# CITY OF PORTLAND

# BUILDING PERMIT

Job ID: 2012-01-3165-ALTR

has permission to build a 15 by 18 foot living room addition.

NEW ADDITION - ROOF FRAMING PLAN

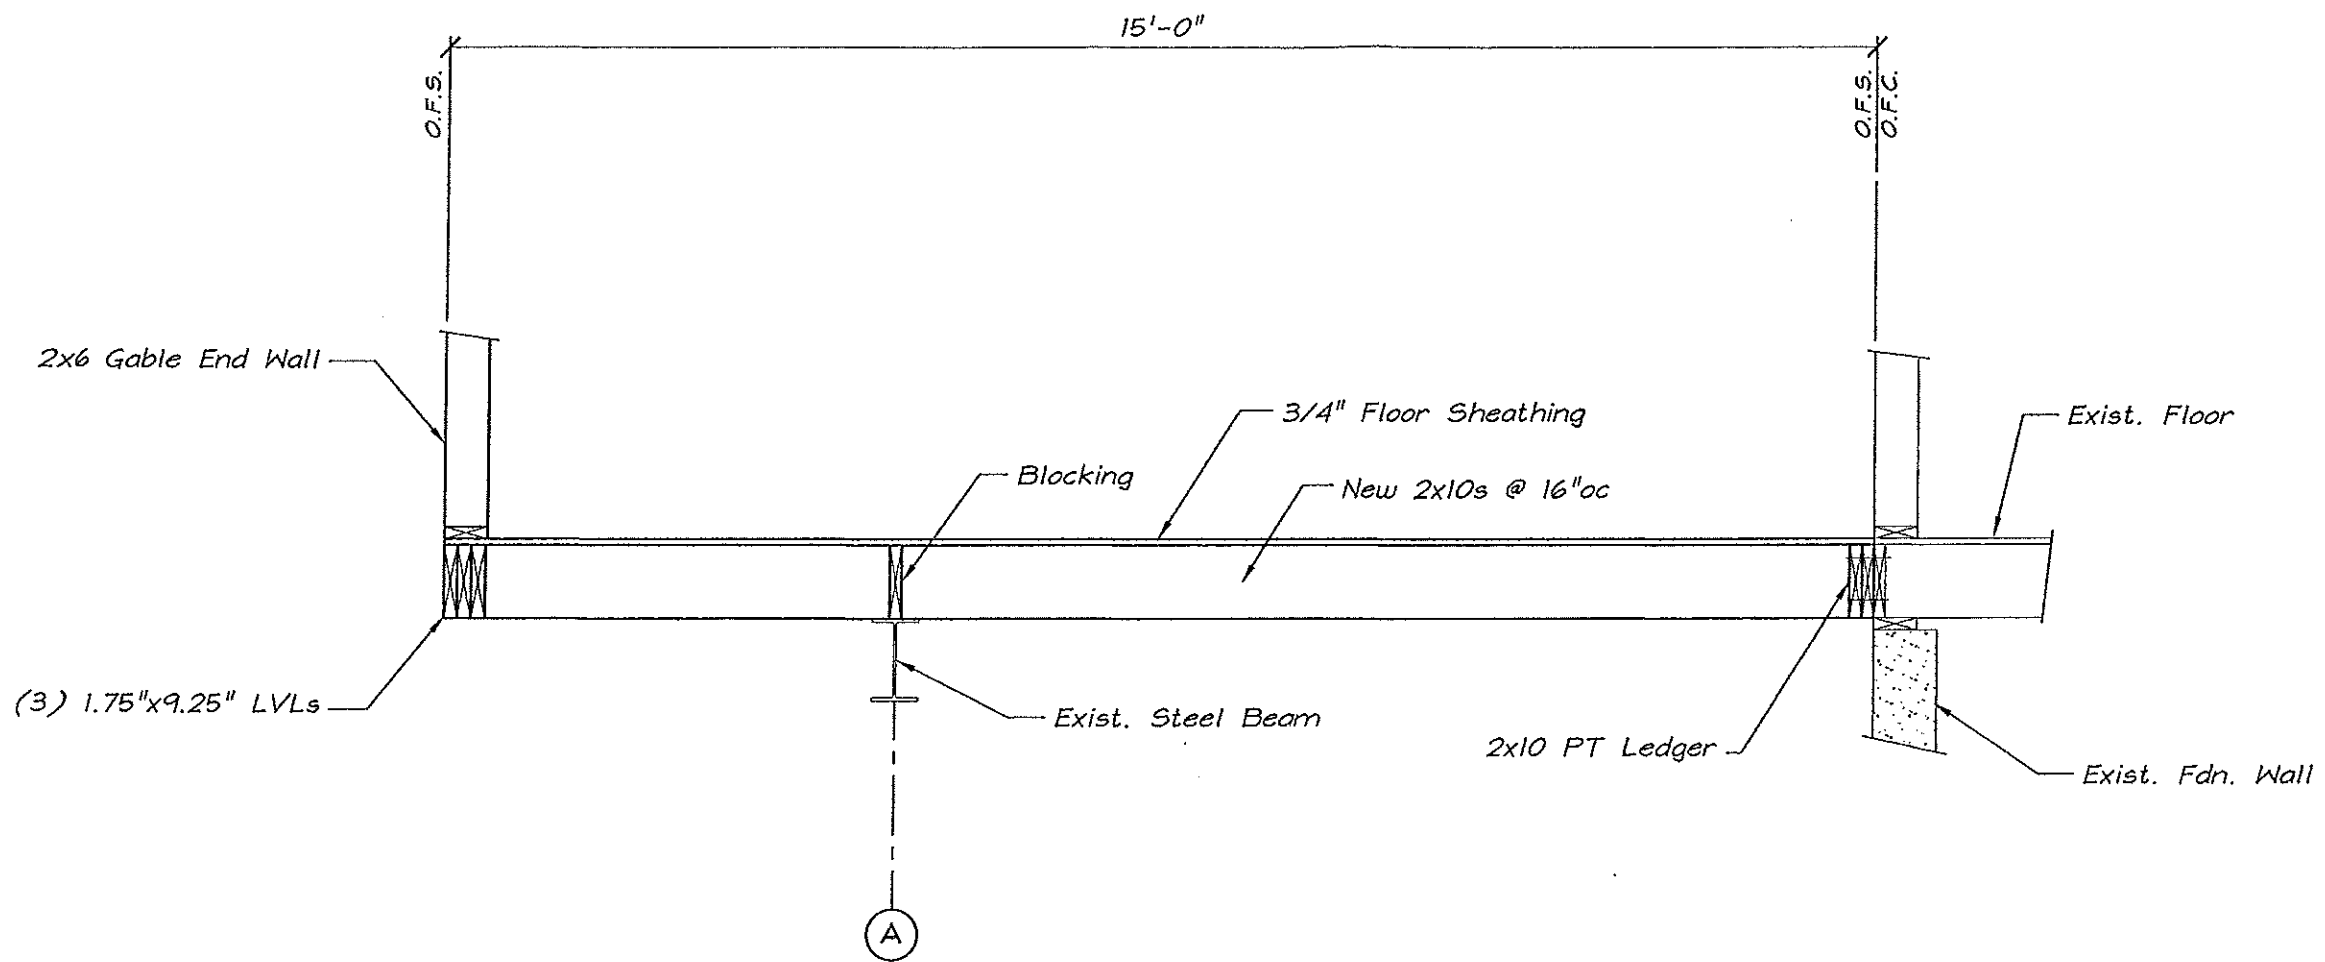
2. Roof Rafter framing and Connection shall comply with Section R802.3 & R802.3.1 of MUBEC.
3. A Carbon Monoxide (CO) alarms shall be installed in each area within or giving access to bedrooms. That detection must be powered by the electrical service (plug-in or hardwired) in the building and battery.

A1

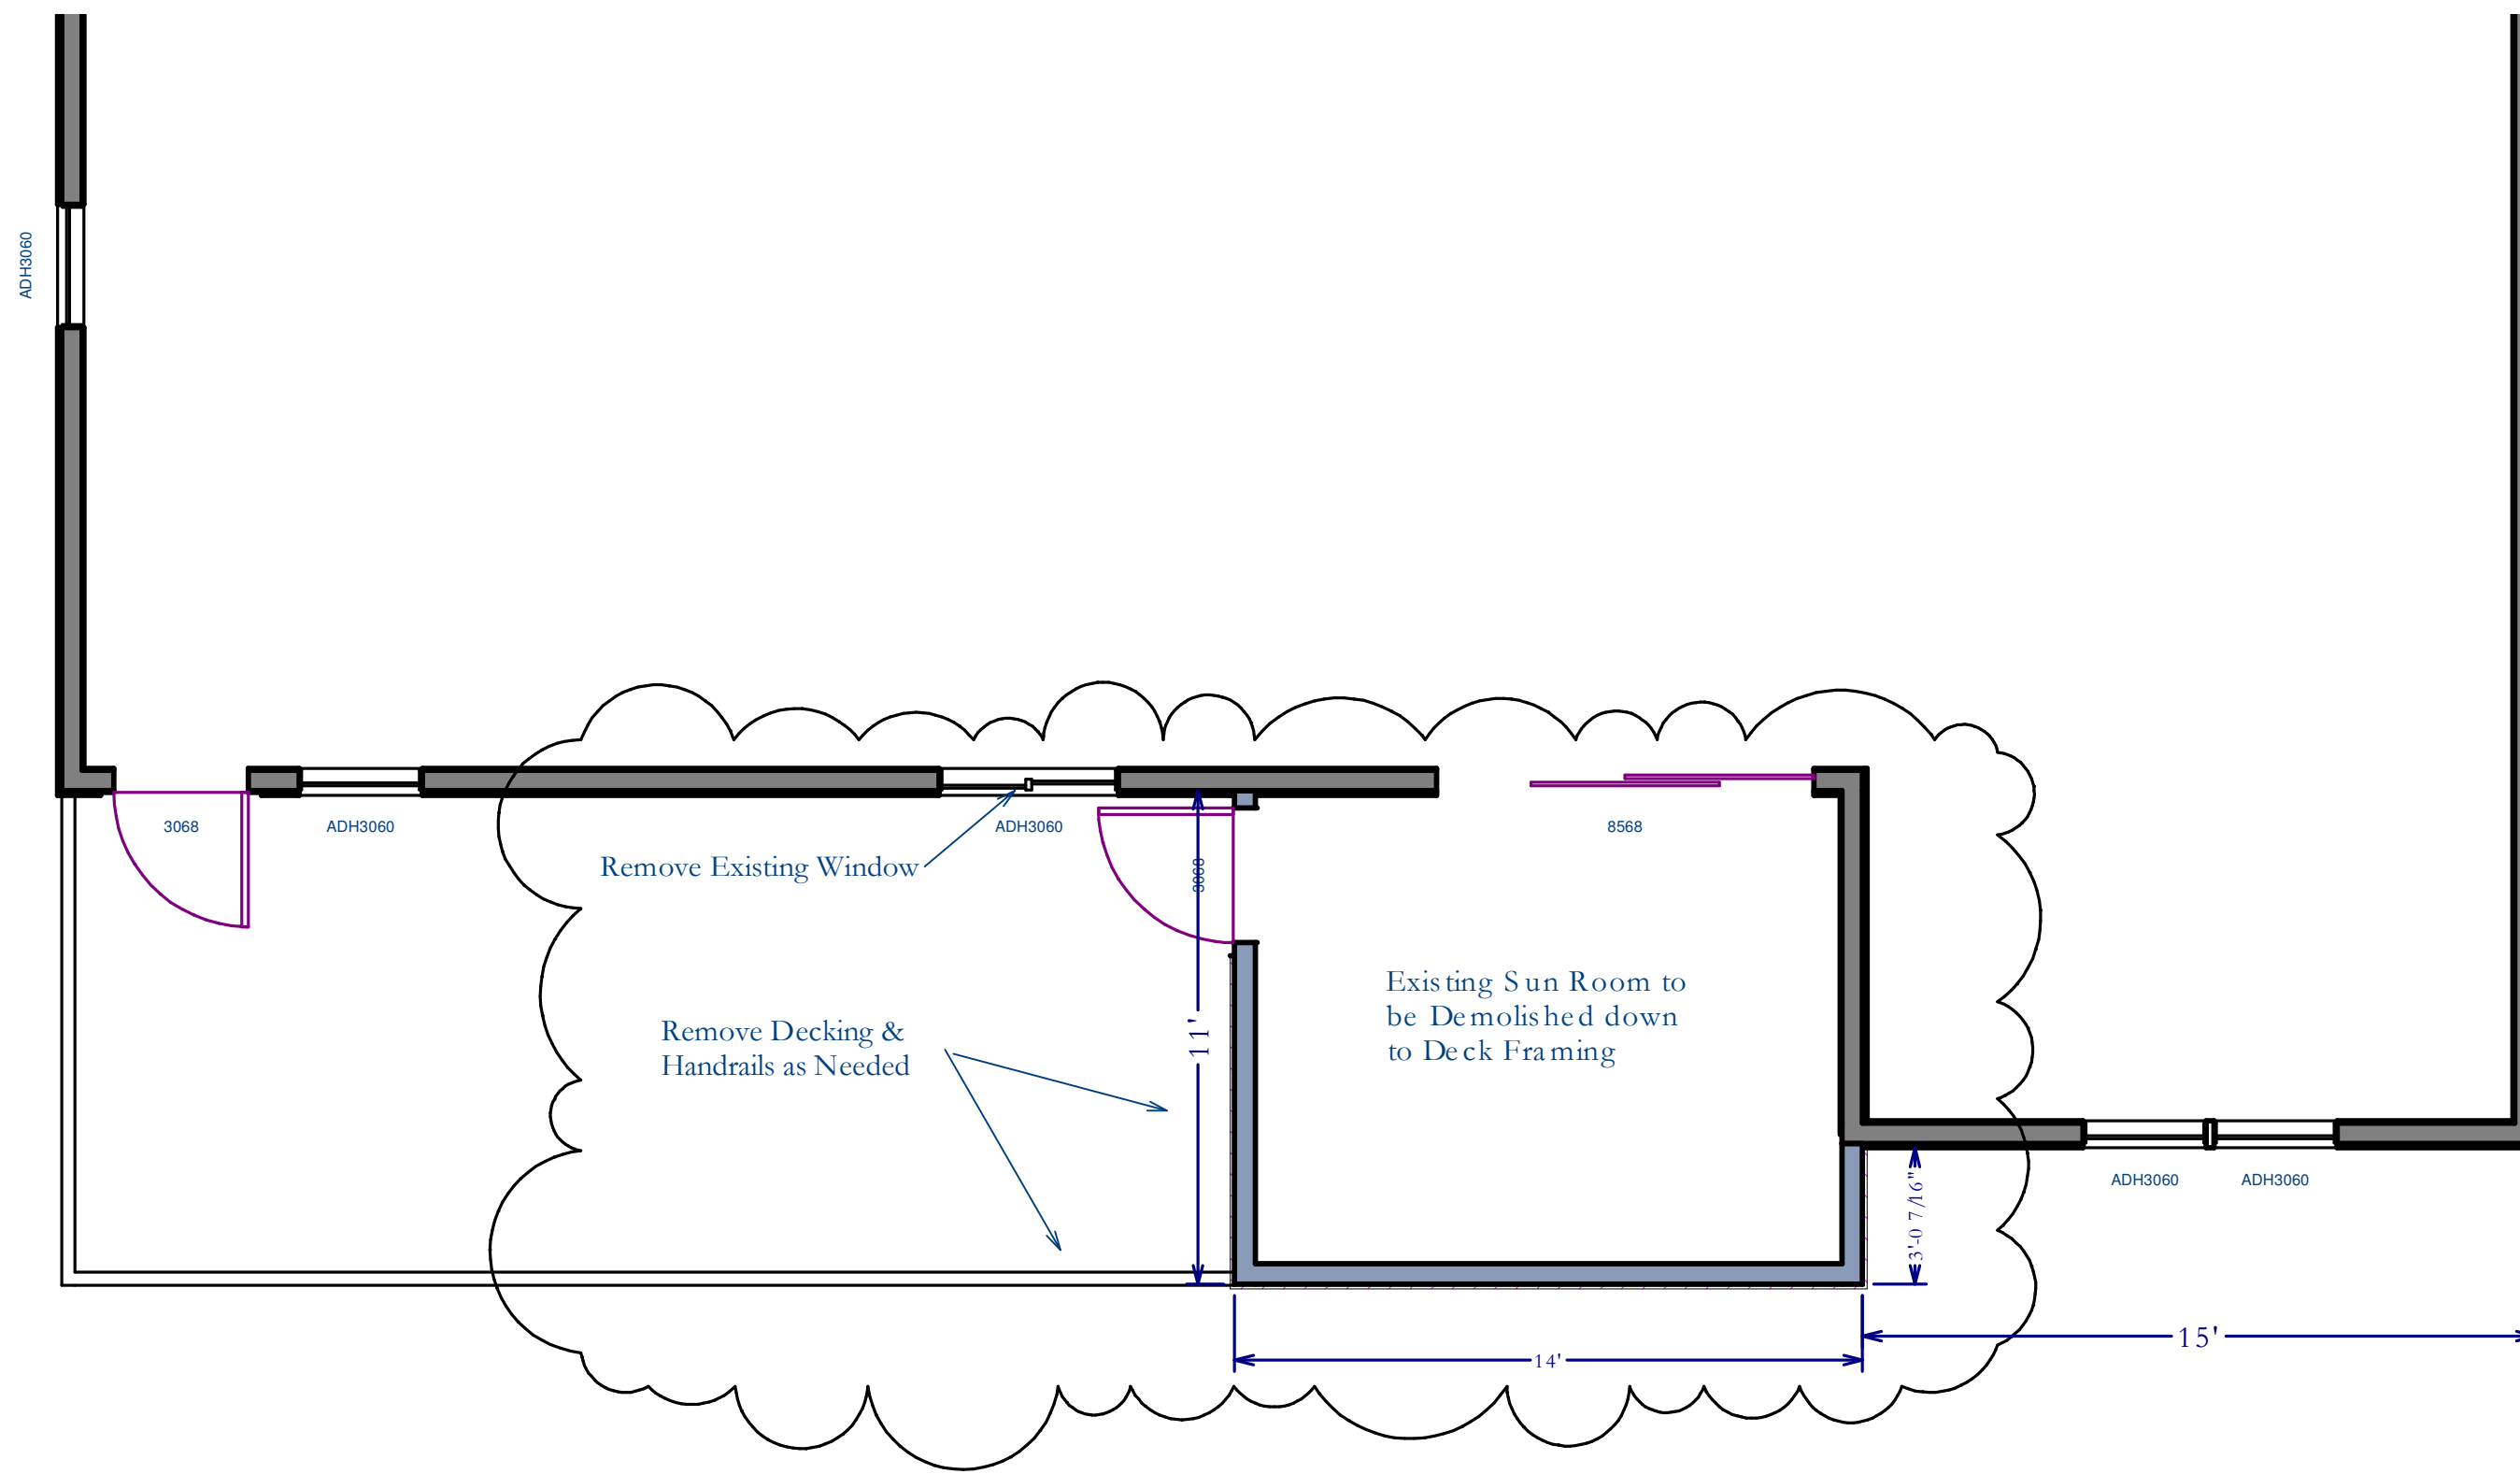
6. Frost protection must be installed per the enclosed detail as discussed w/owner/contractor (at least 4' from grade).
7. Glazing in an individual fixed or operable panel adjacent to a door where the nearest vertical edge is within a 24-inch arc of the door in a closed position and whose bottom edge is less than 60 inches above the floor or walking surface. **See attached documentation, Section R308 for Safety Glazing requirements.**
8. Note: The existing deck adjacent to the proposed Sunroom will not be altered; there is only interior access to the proposed Sunroom (no new exterior steps); the new addition "does not" create a crawl space; existing header will be utilize from the removed interior doorway.

Glazing: Needs safety glazing @ Windo adj to door

Glazing: Gable windows need fall protection R612.3 - ASTM F~~1~~2090
